Consultee Comments for Planning Application 24/00755/FUL

Application Number: 24/00755/FUL

Address: 34 South Street Chichester West Sussex PO19 1EL

Proposal: Installation of a roof window.

Front and rear elevations

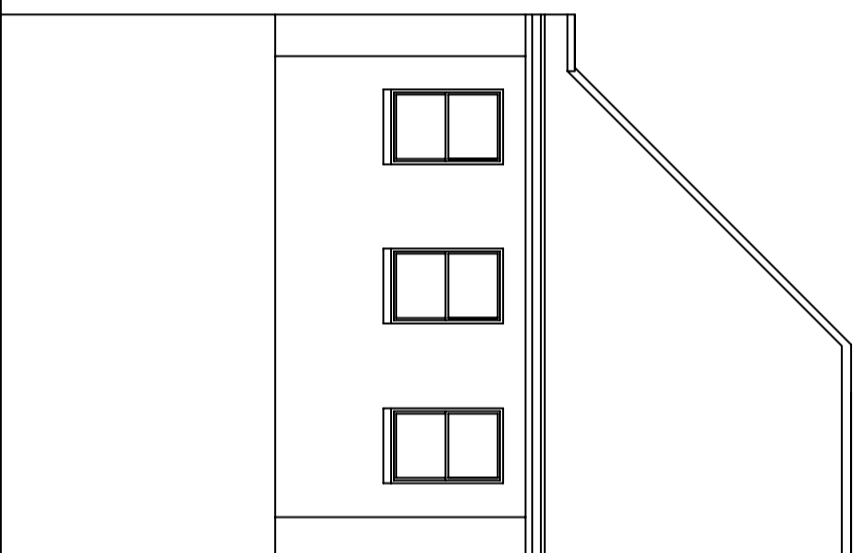
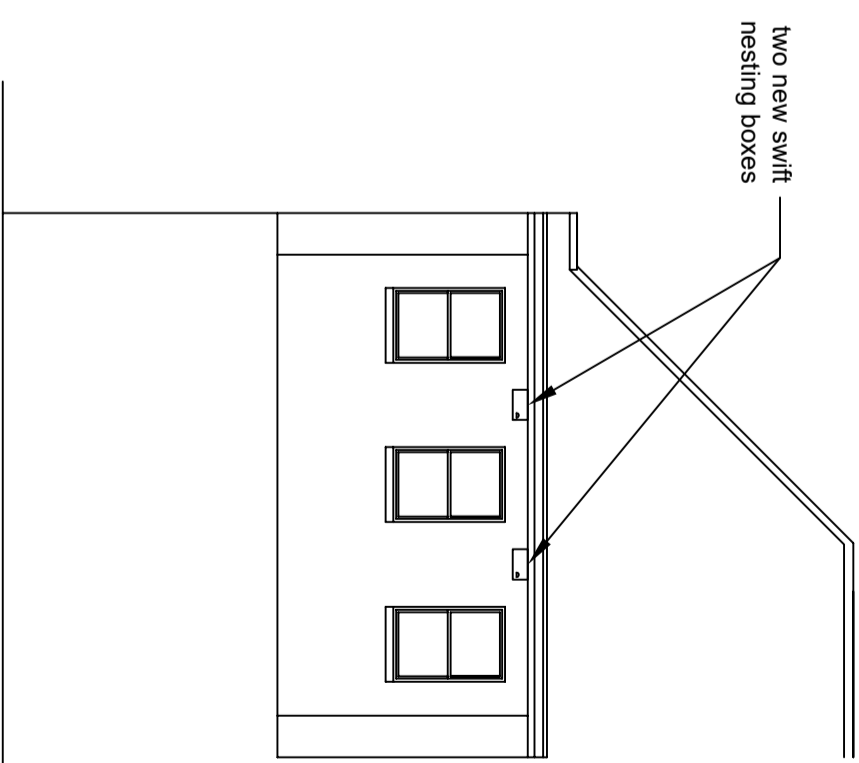
We would like a bird box to be installed on the building / and or tree within the site.
